J.S. THOMPSON  
ENGINEERING, INC

September 5, 2024

The "Wells" plan was reviewed for lot #43 West Preserve subdivision (116 Boyce Ct.) in Sanford, North Carolina to address adding a cased opening between the garages.

FIRST FLOOR PLAN
 1/4" = 1'-0" CEILING HT. = 9'-0"

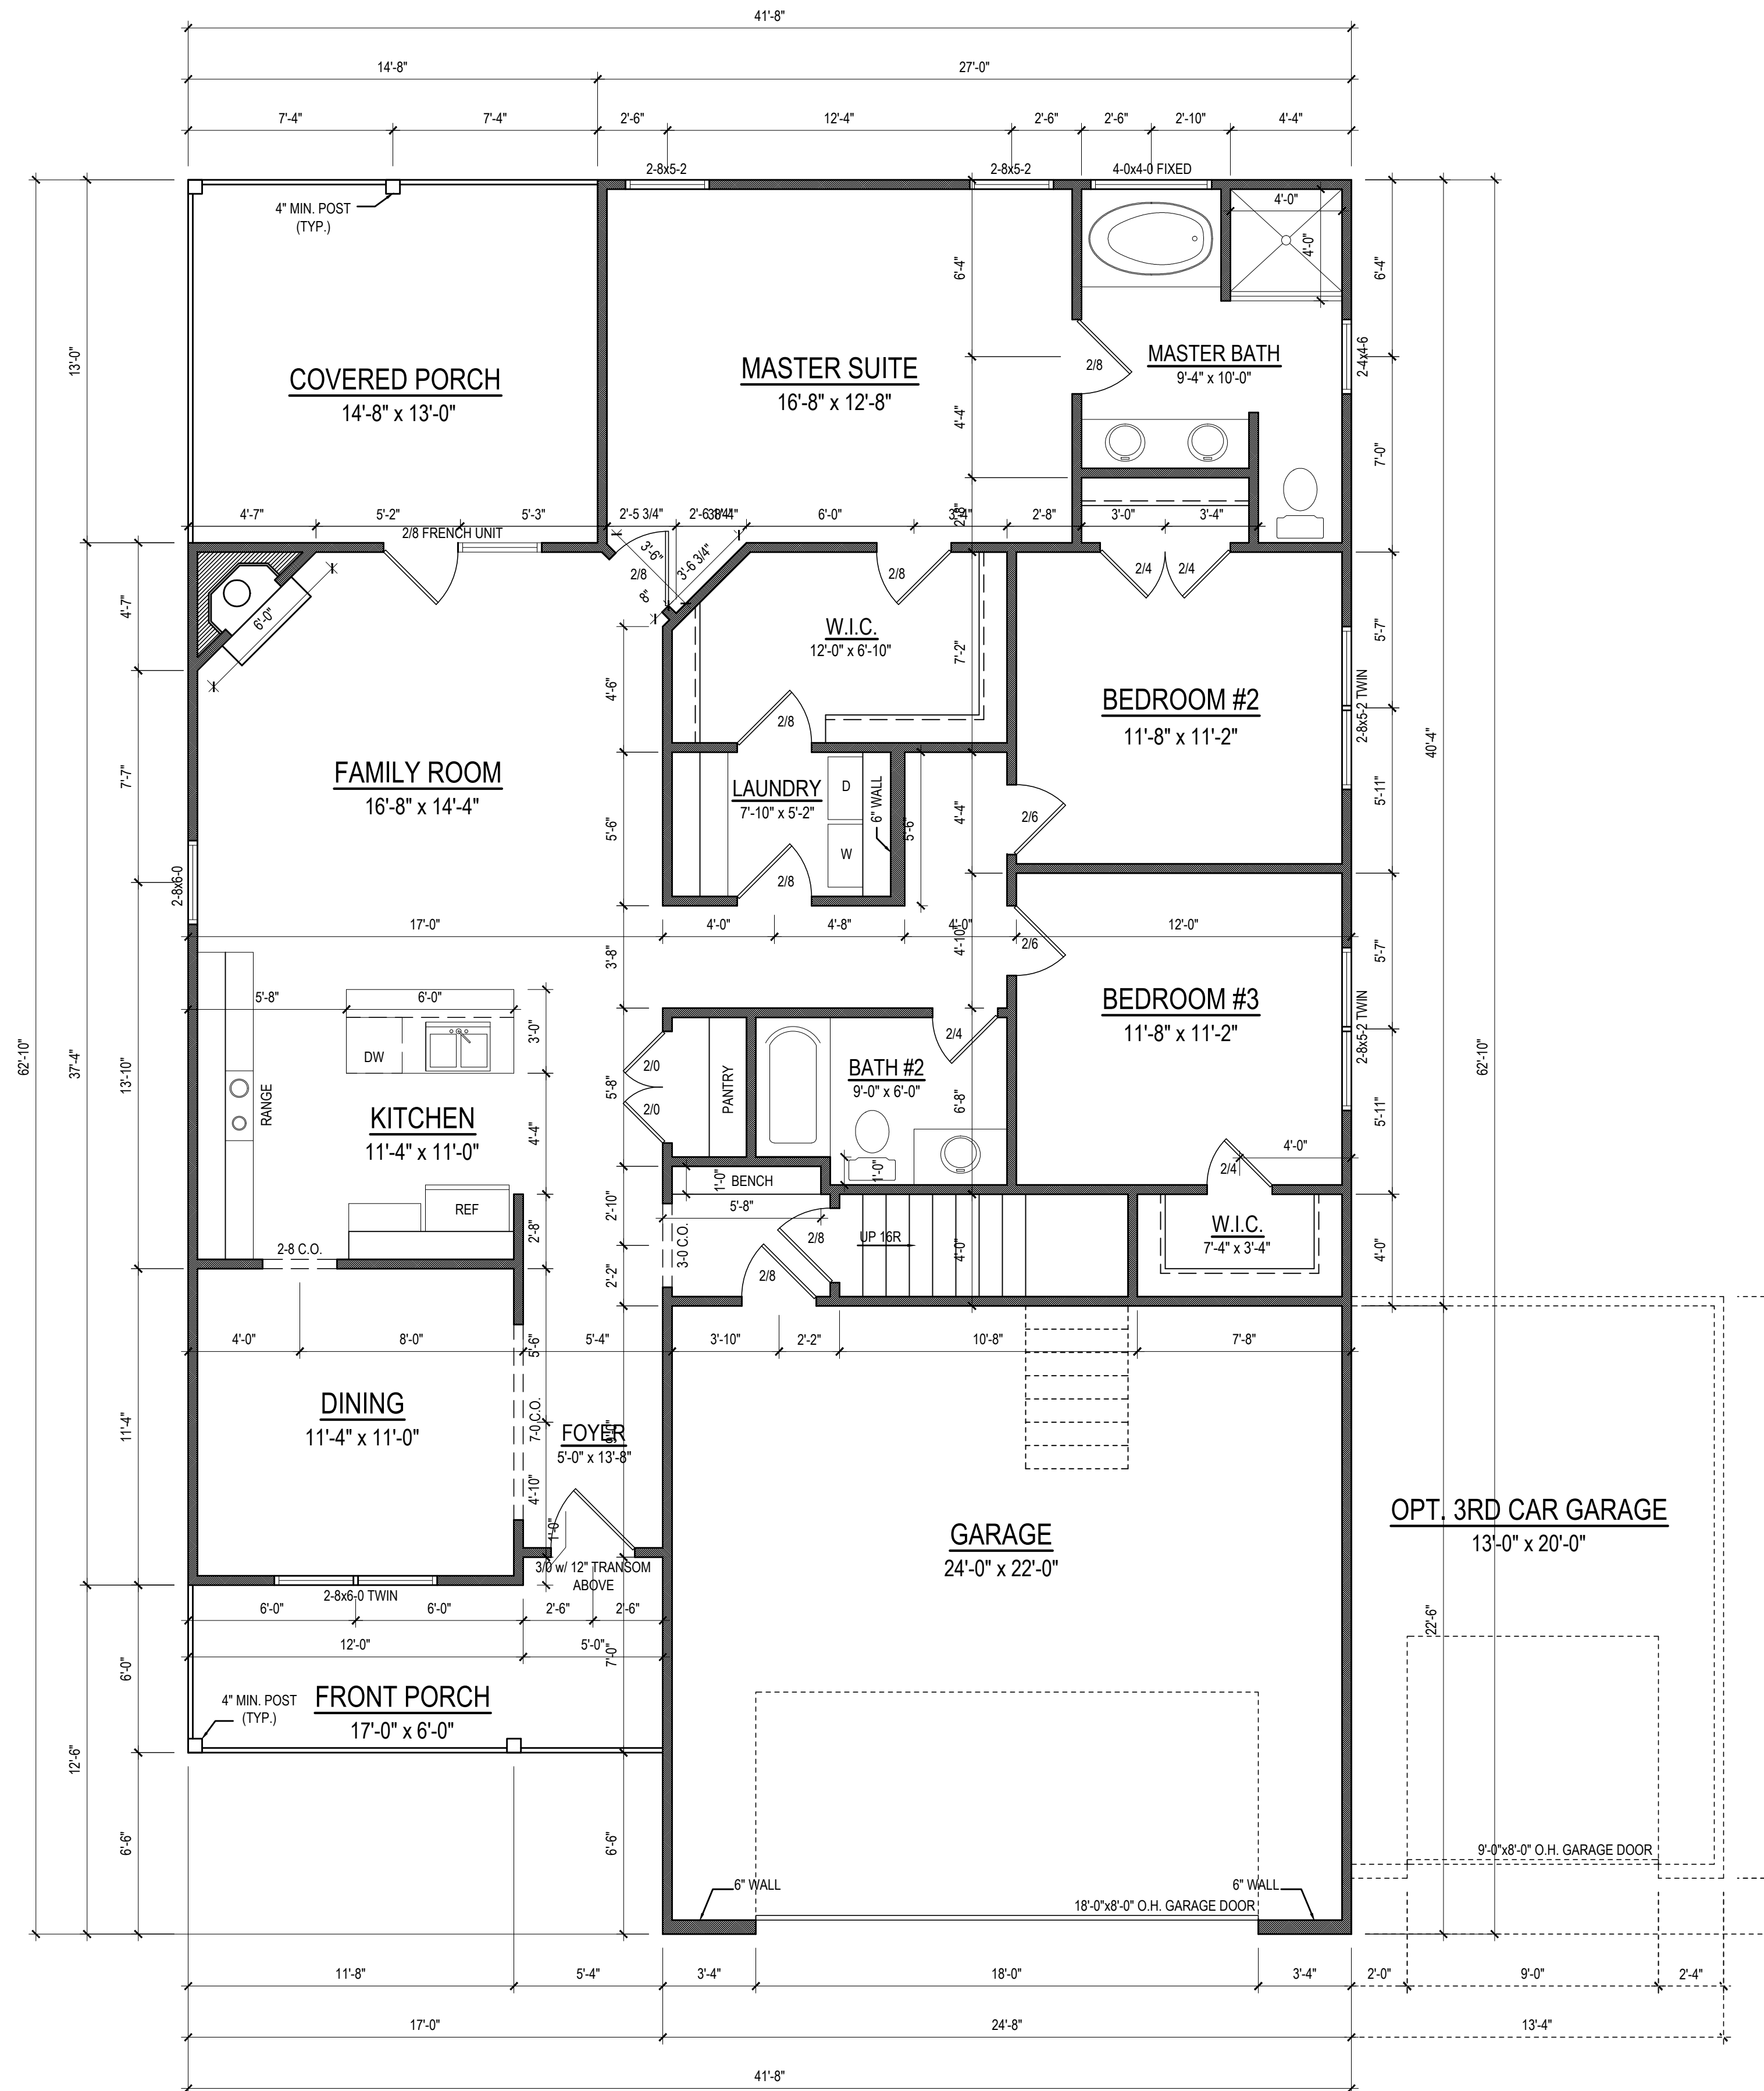
A 8/0 cased opening with a (2) 1 3/4" x 9 1/4" LVL header may be added in the location between the garages indicated on the architectural plan (see excerpt below). The LVL header is to be supported by (2) SPF #2 jacks and (1) SPF #2 king stud at each end. The continuous lug footing beneath the opening is suitable per plan. This configuration will provide the required support for all applied loads.
